1 SC Responses to City of Colorado Springs plan redlines.

NEW TRAFFIC CONTROL SIGNAL PLAN
Mast-Arm Traffic Signal Plan Sheet
Marksheffel Road & Lorson Boulevard

LSC Responses to City of Colorado Springs Redlines

NEW TRAFFIC CONTROL SIGNAL PLAN  
Mast-Arm Traffic Signal Plan Sheet  
Marksheffel Road & Lorson Boulevard

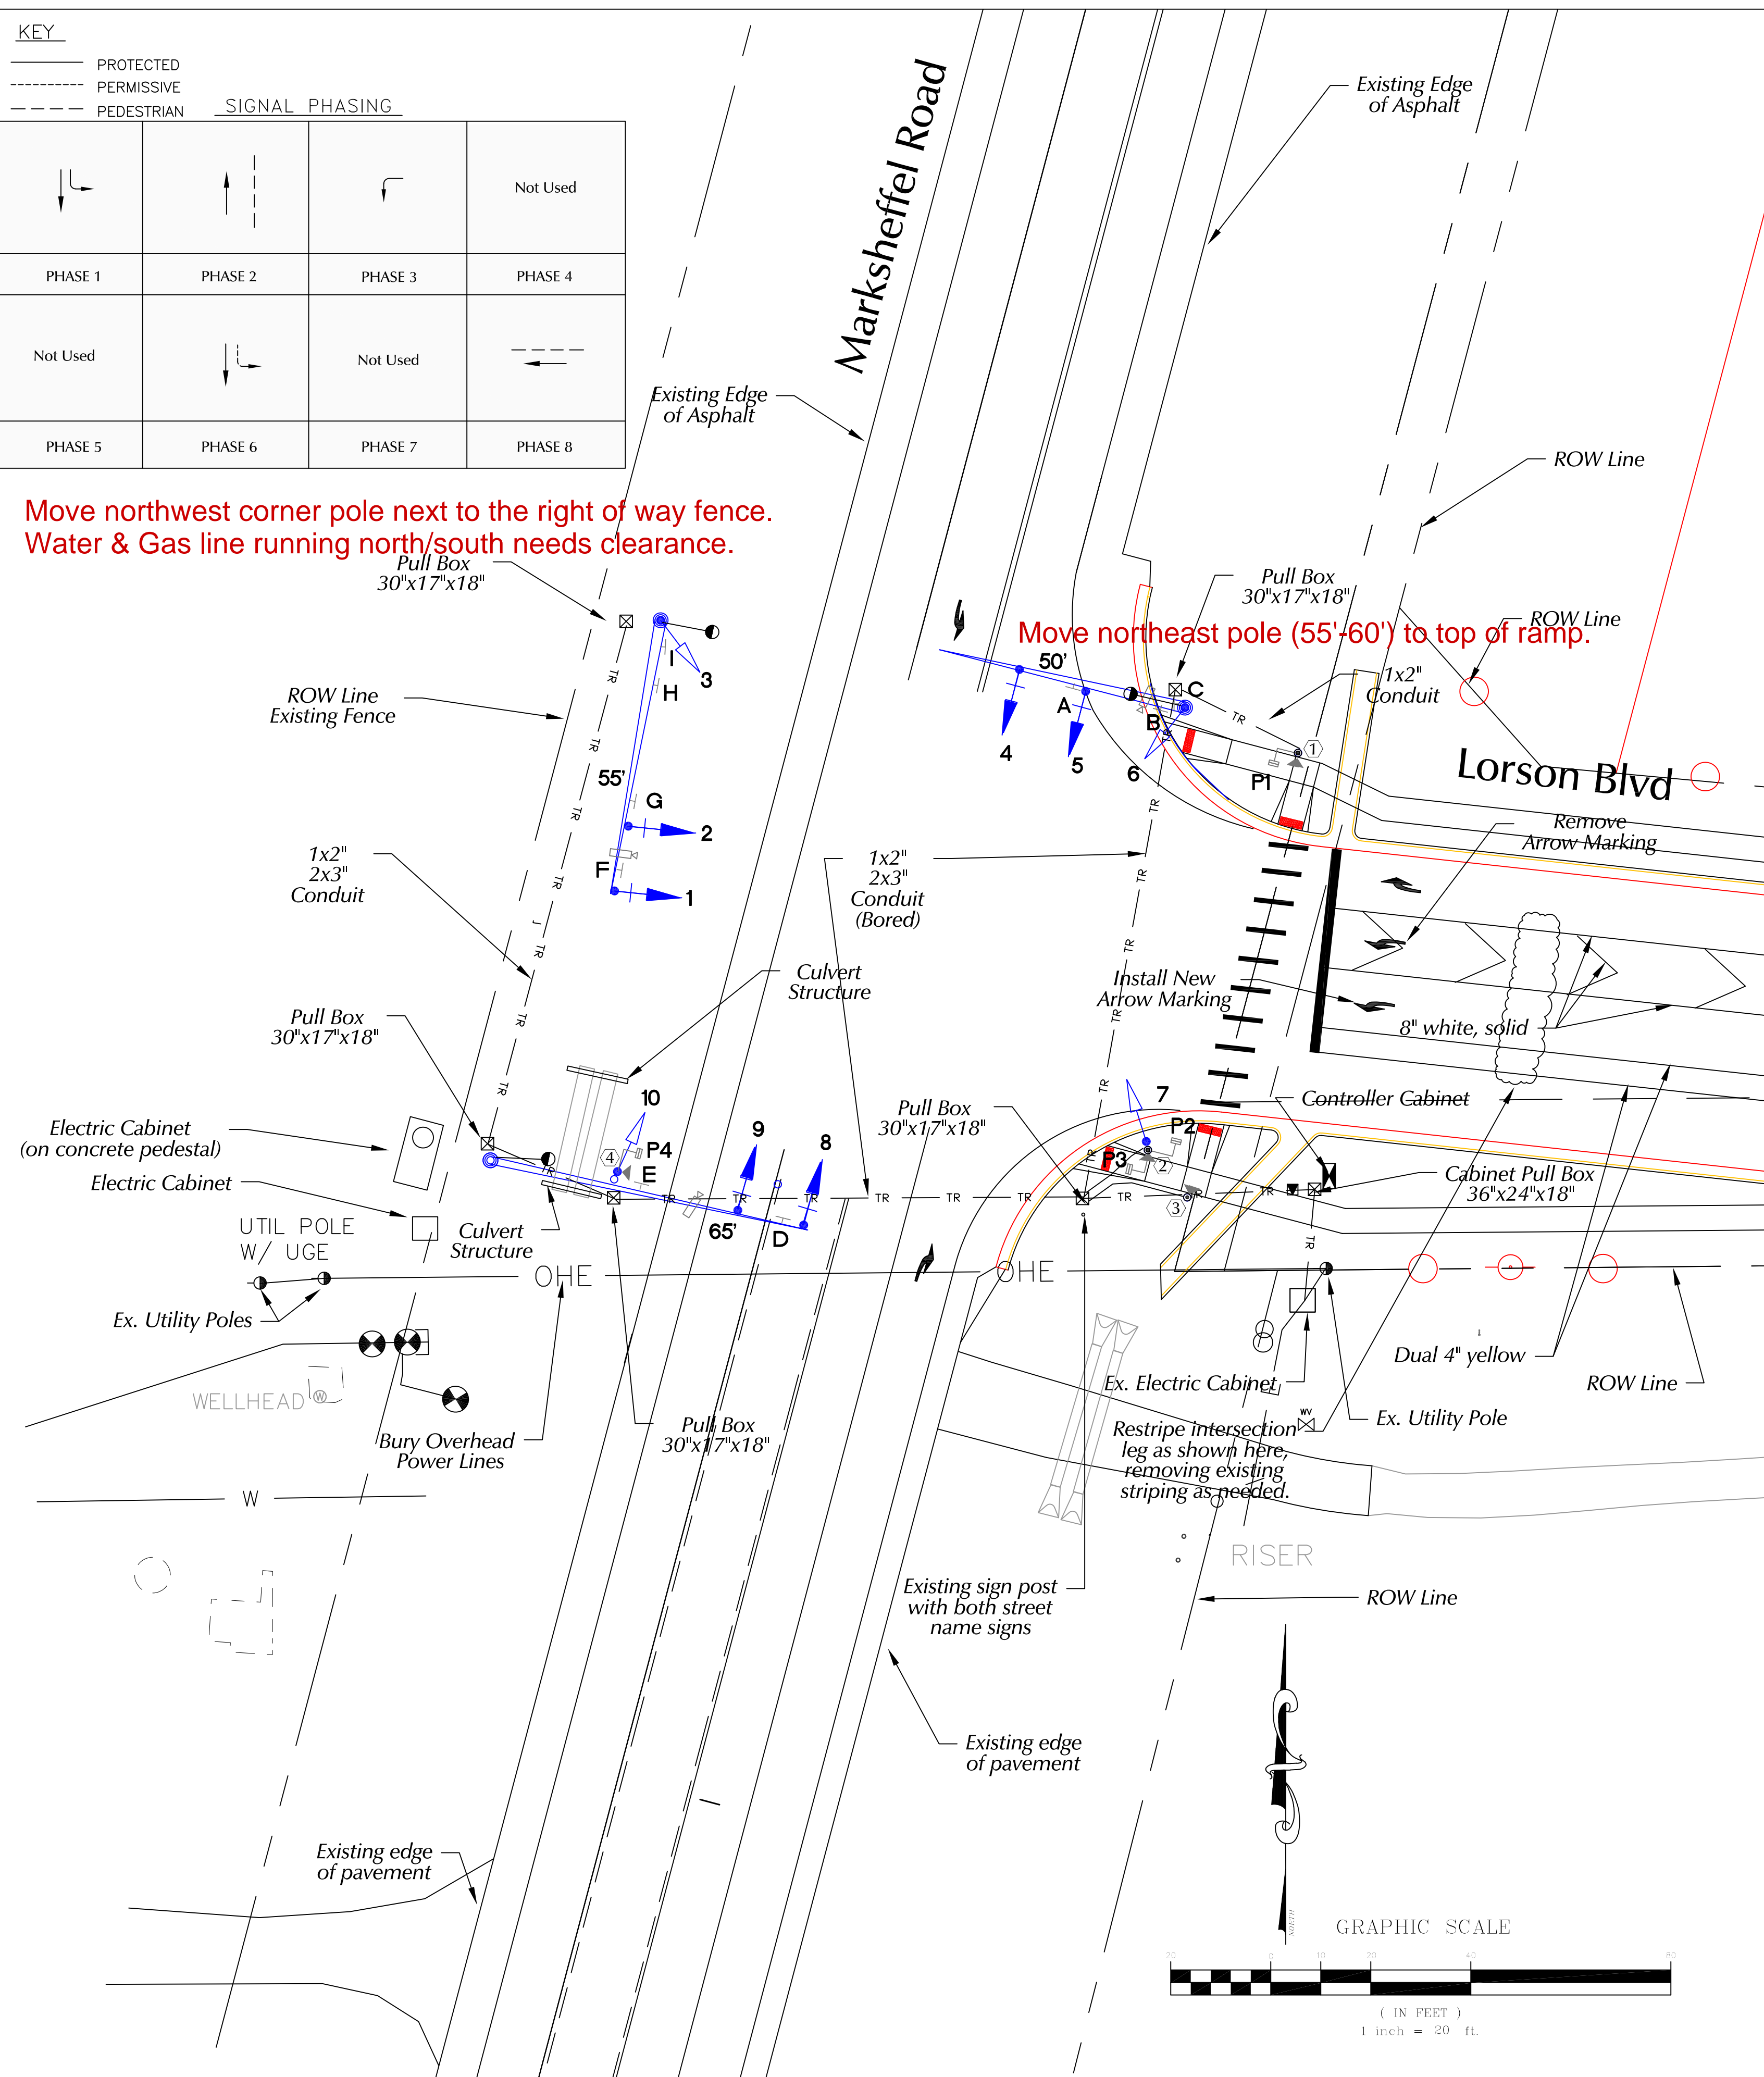
Move northwest corner pole next to the right of way fence.
Water & Gas line running north/south needs clearance.

Move northeast pole (55'-60') to top of ramp.

LSC Response: This pole has been moved on the plans, as requested.

LSC Response: This pole has been moved to the top of the ramp, as requested. The mast arm on this northeast corner pole has been revised to a 60' length and the caisson diameter has been changed.

LSC Note: This has been revised.

LSC Note: This row has been deleted.

LSC Note: These have been revised.
